Falcon Storage Expansion Transportation Memorandum

Please add PCD File No. MS232
& PPR2232

LSC #S214430

LSC Responses to Falcon RV Storage -- EPC Redline Comments

Figure 2 Site Plan

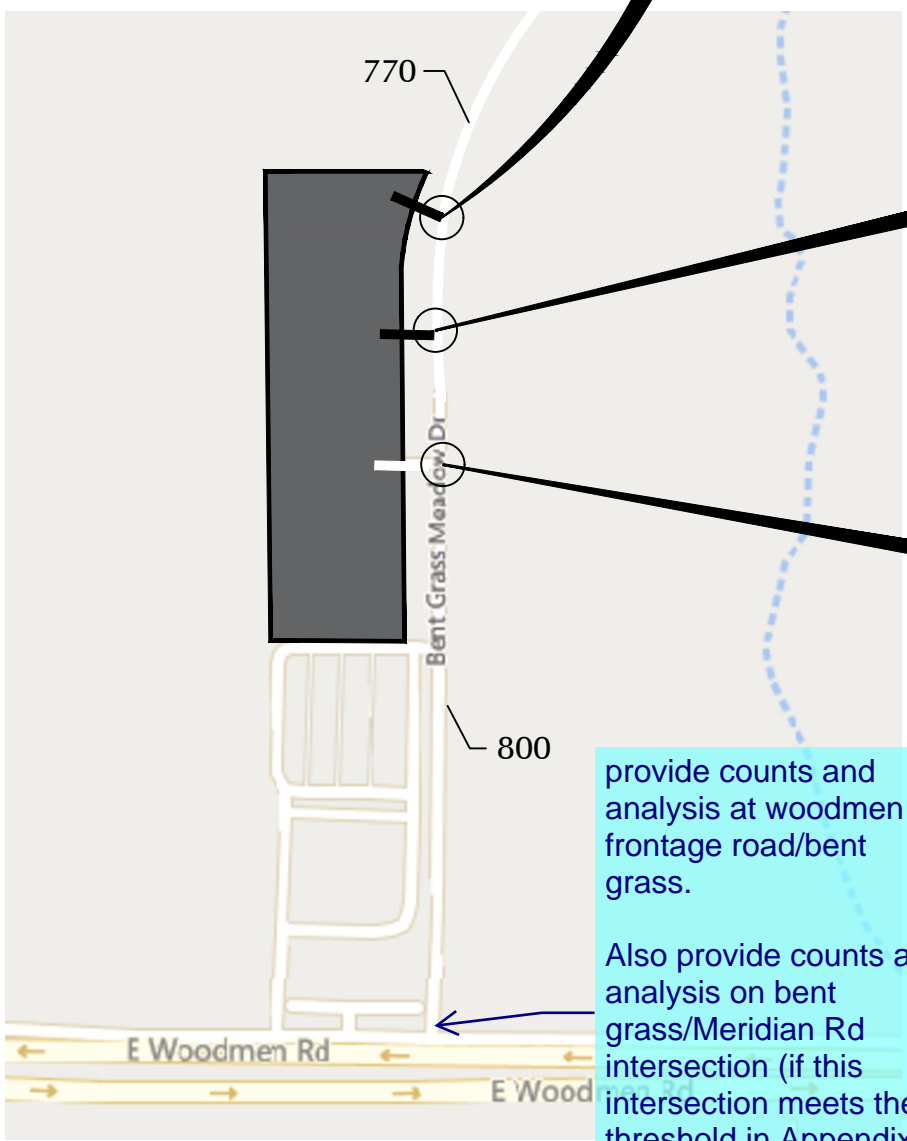
only a single access is proposed on the most recent site development plan. Revise accordingly.

revise accordingly as a single new access point is provided. Please update throughout the narrative.

Please update the site plan to match the current proposed plan showing a single new access point

LSC Response: The TIS has been updated accordingly.

Author: jchodsdon Subject: Sticky Note Date: 7/17/2023 9:17:02 AM
LSC Response: The TIS has been updated accordingly.

Figure 1b

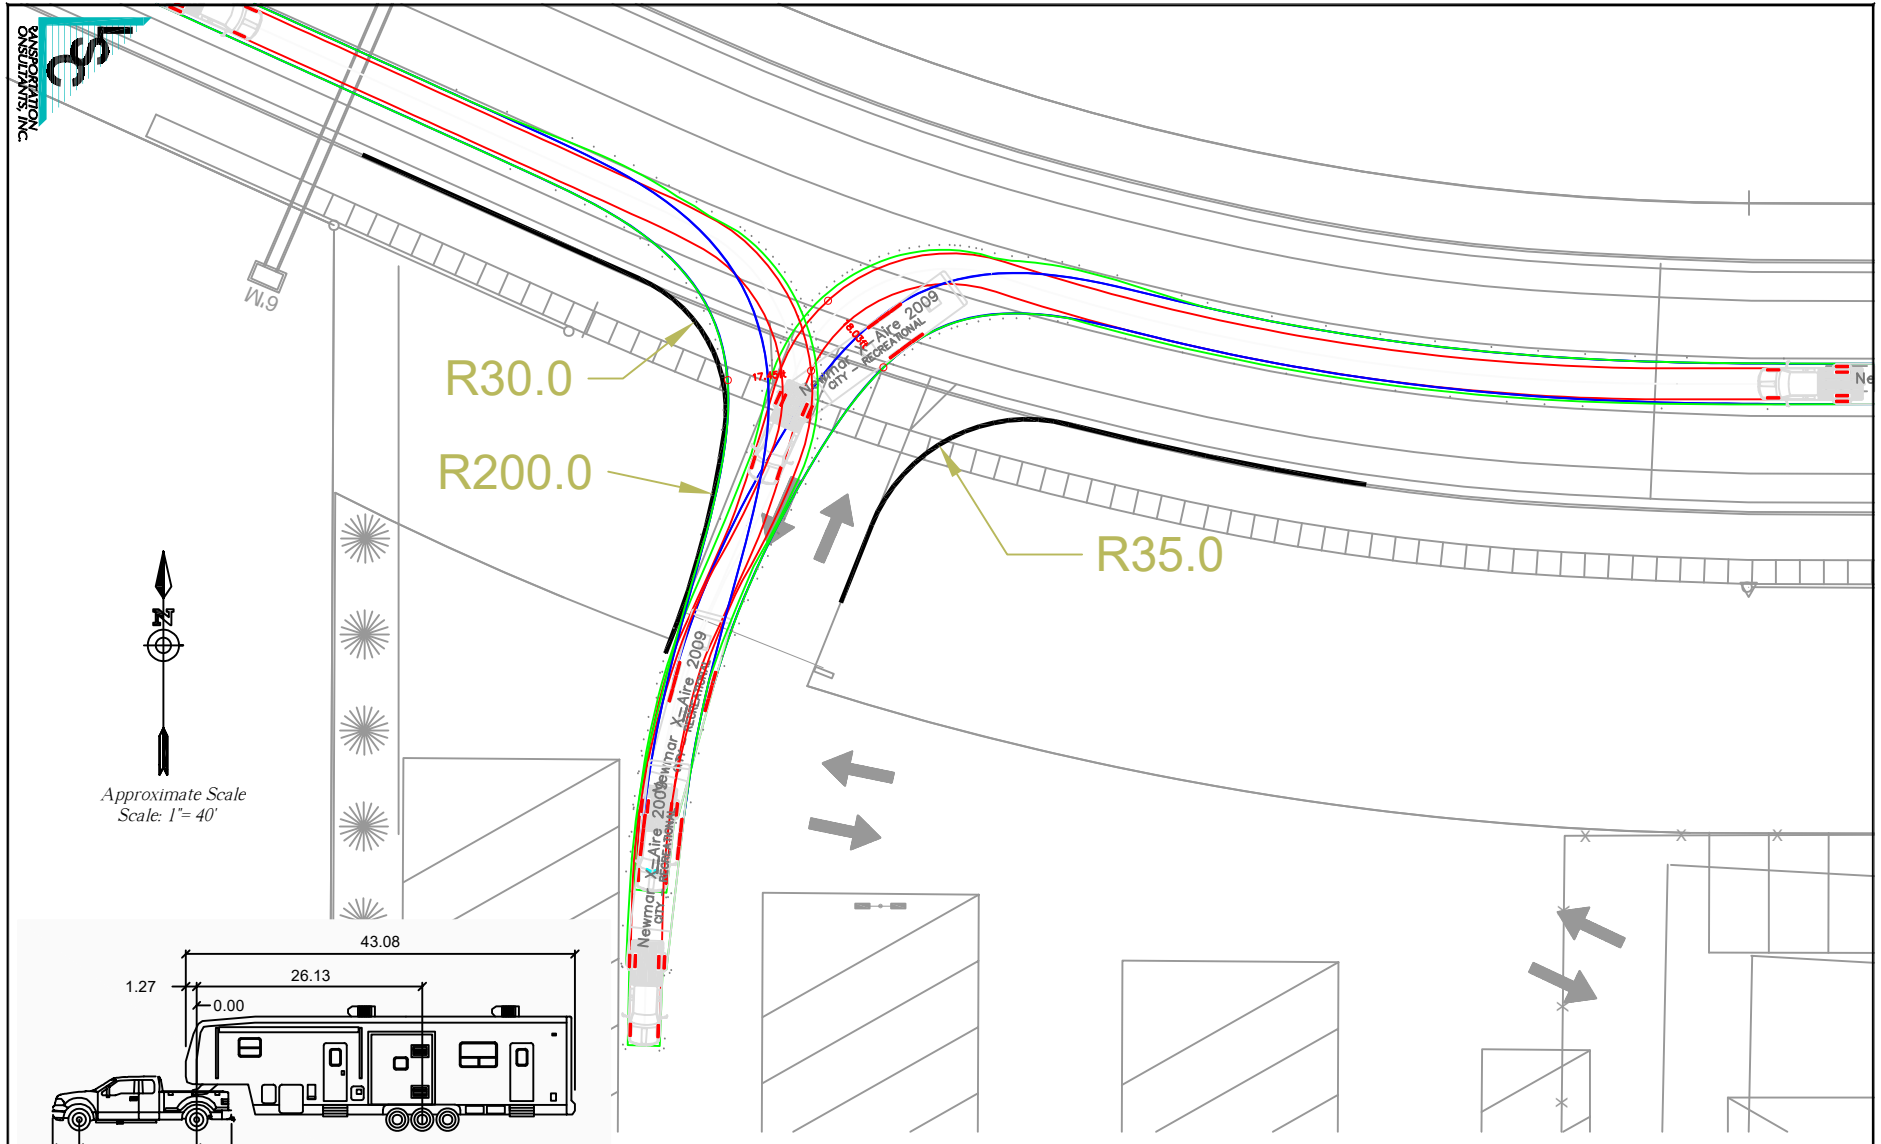
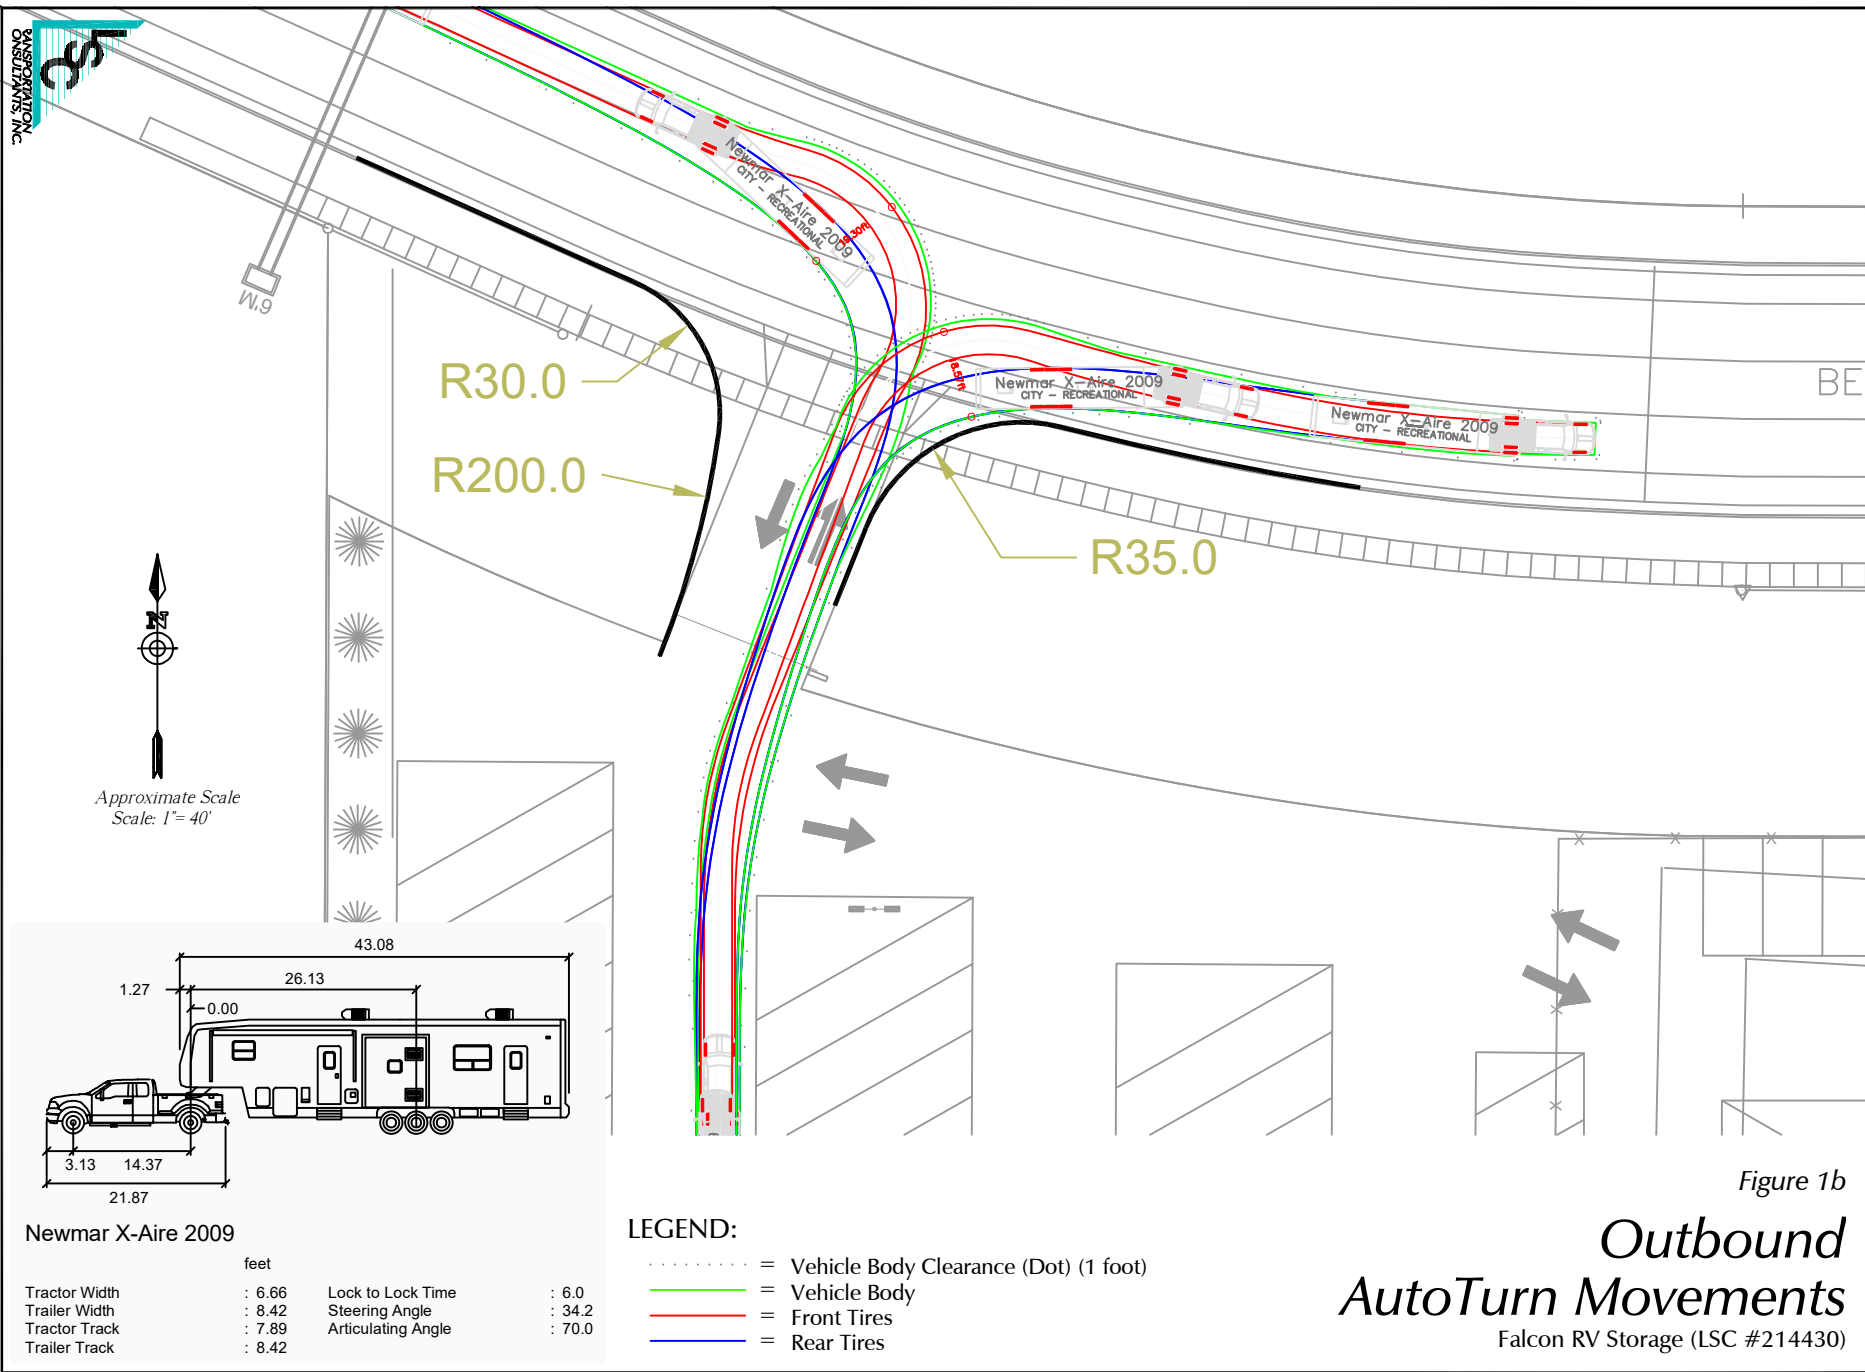
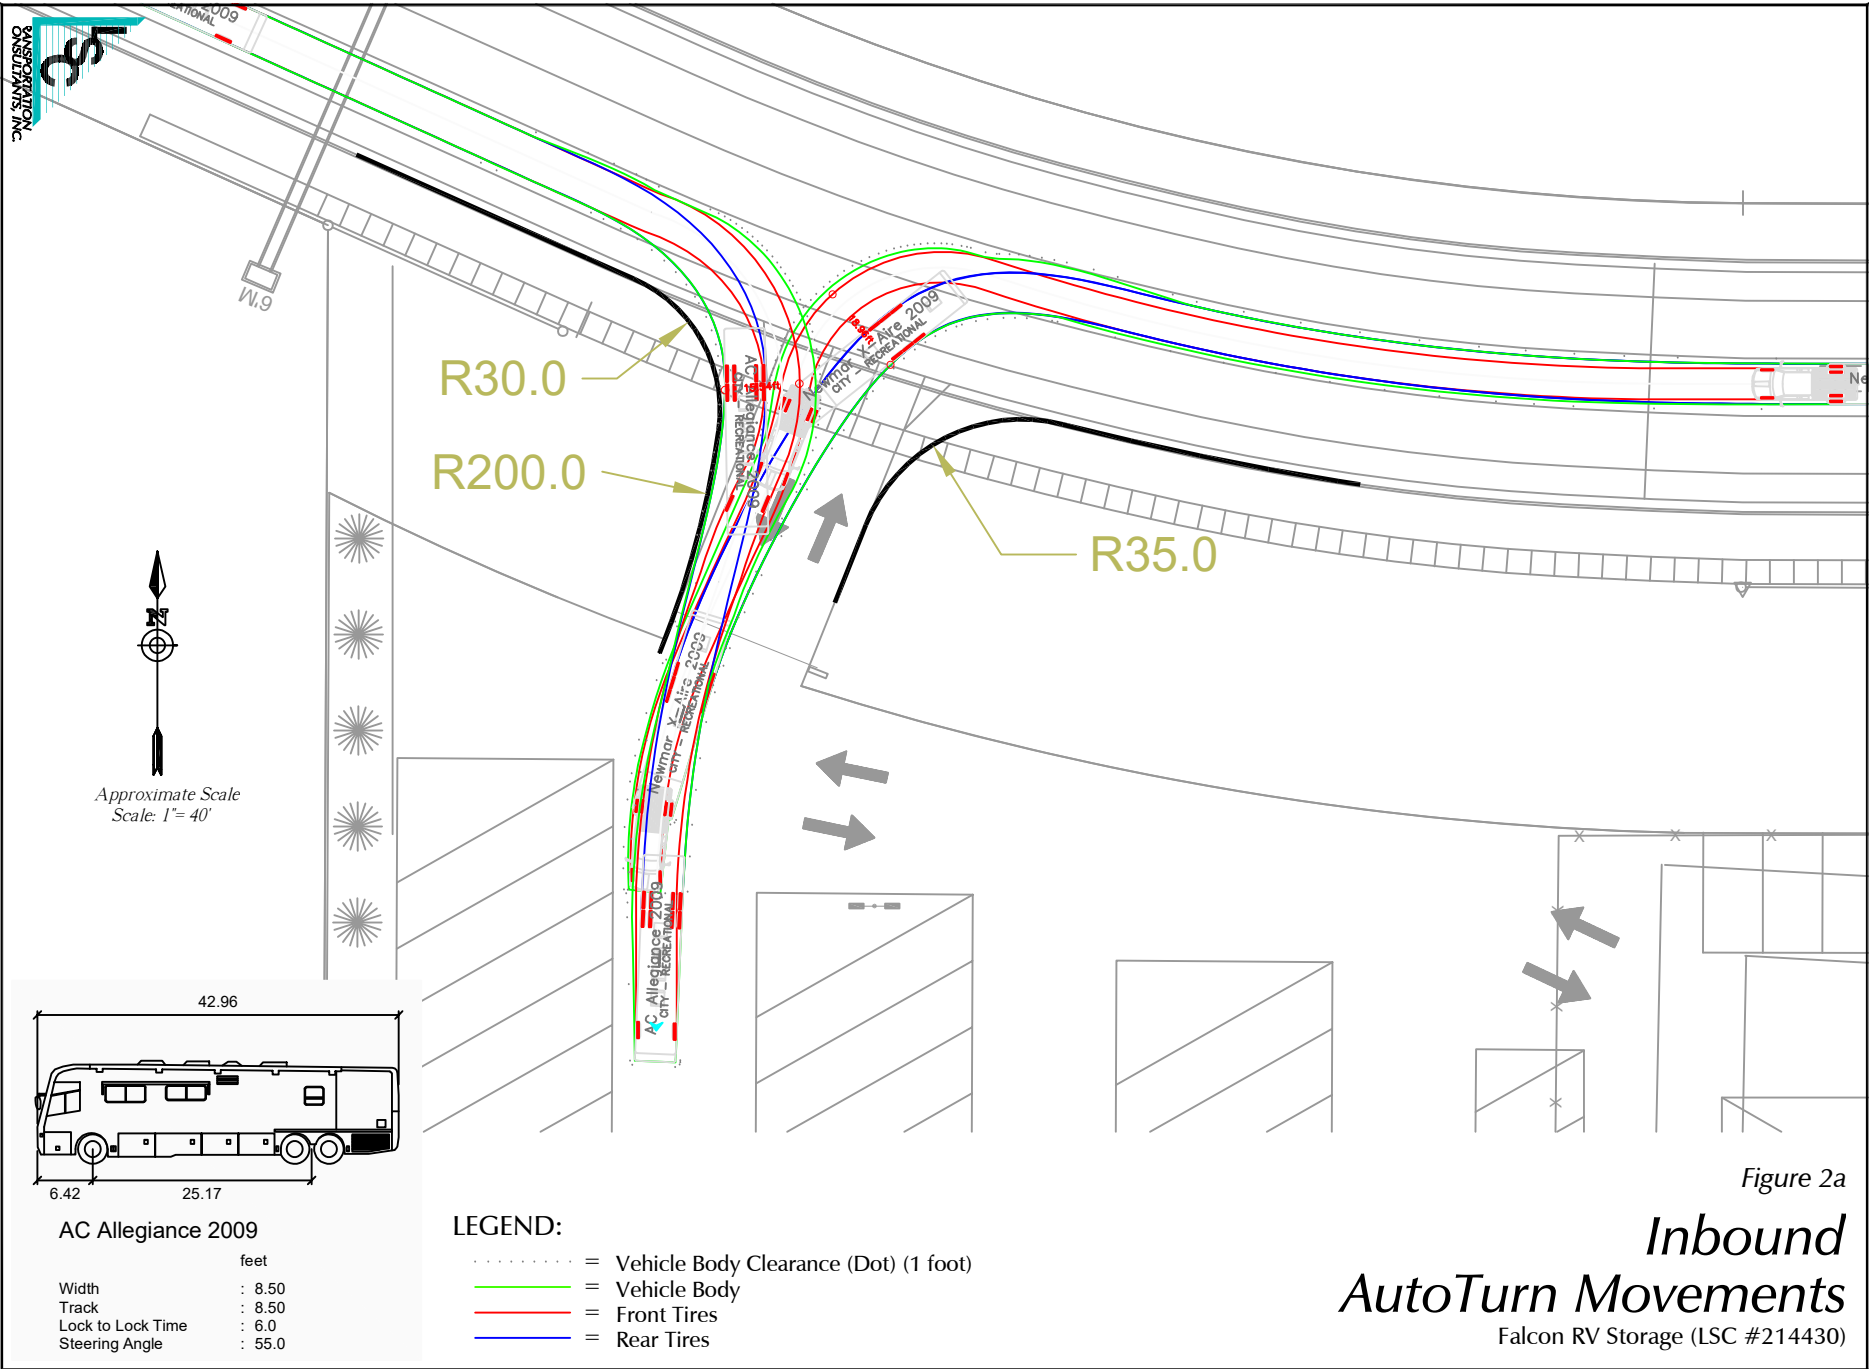
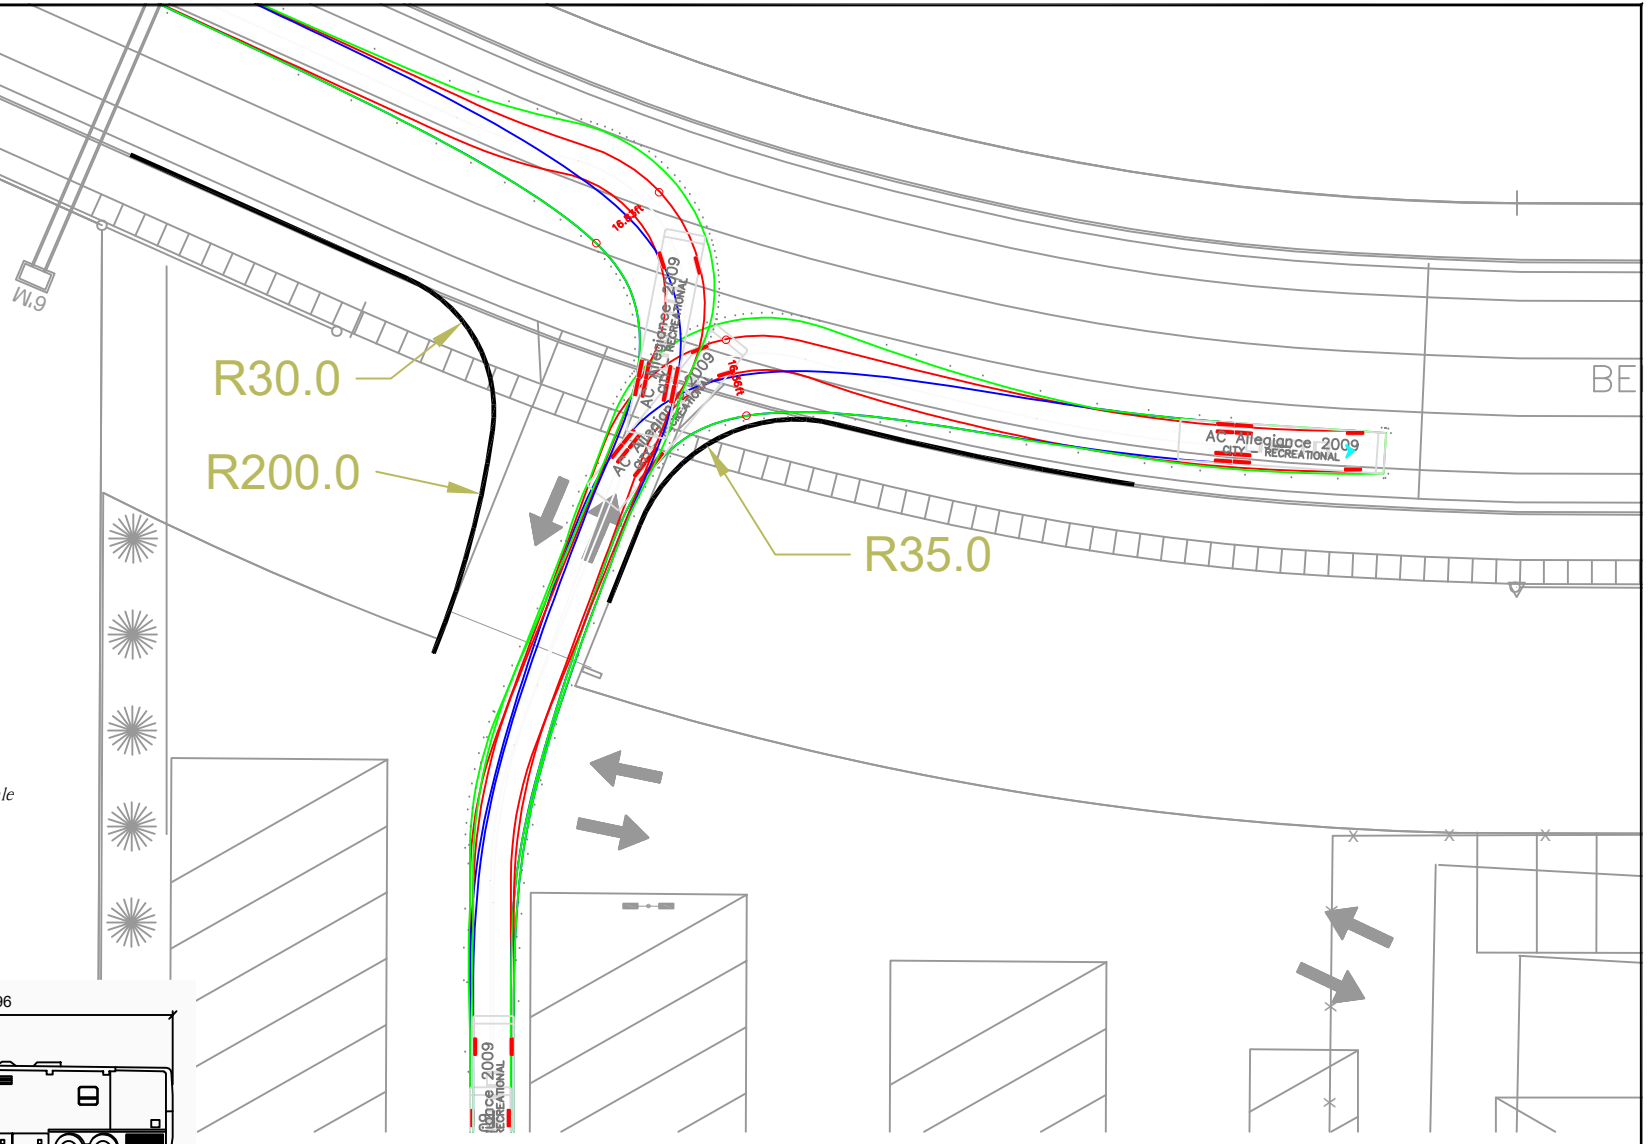
[Provide auto turn exhibit and provide recommendations for the radii at the proposed access.](#)

LSC Response: Included as requested.
